Re: Planning Application 19/0063

Address: Land off Higher Road Longridge PR3 2YX

Description: Regularisation of existing, unauthorised agricultural access.

Block Plan 1:500

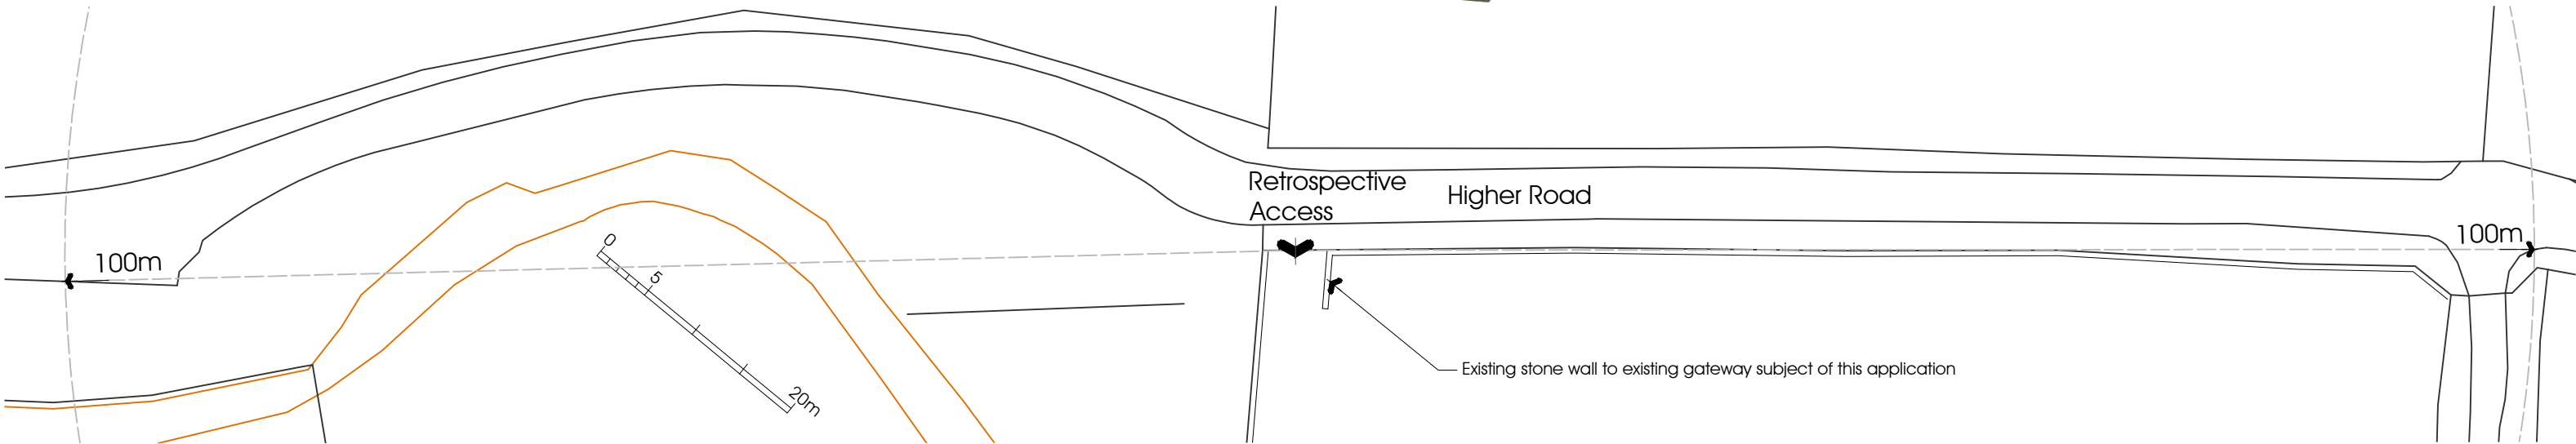
There are concerns regarding the visibility of the access due to the proximity of the drystone wall, and the soundness of the ground that forms the access.

1. Before the access is used for vehicular purposes, any gateposts erected at the access shall be positioned at least 5m behind the edge of the carriageway. The gates shall open away from the highway. **Reasons:** To permit vehicles to pull clear of the carriageway when entering and exiting the site and to ensure the swing of the gates do not affect the availability for a vehicle to wait off road.

2. Before the access is used for vehicular purposes, that part of the access extending from the highway boundary to the gate shall be appropriately paved in tarmac, concrete, block pavements, or other approved materials. **Reasons:** To prevent loose surface material from being carried on to the public highway thus causing a potential source of danger to other road users.

tree, shrub or other device over 1m above road level. The visibility splay to be the subject of this condition shall be that land in front of a line drawn from a point 2.4m measured along the centre line of the proposed access from the continuation of the nearer edge of the carriageway of 2 to points measured 100m in each direction along the nearer edge of the carriageway of Higher Road, from the centre line of the access. Reason: To ensure adequate visibility at the street junction or site access.
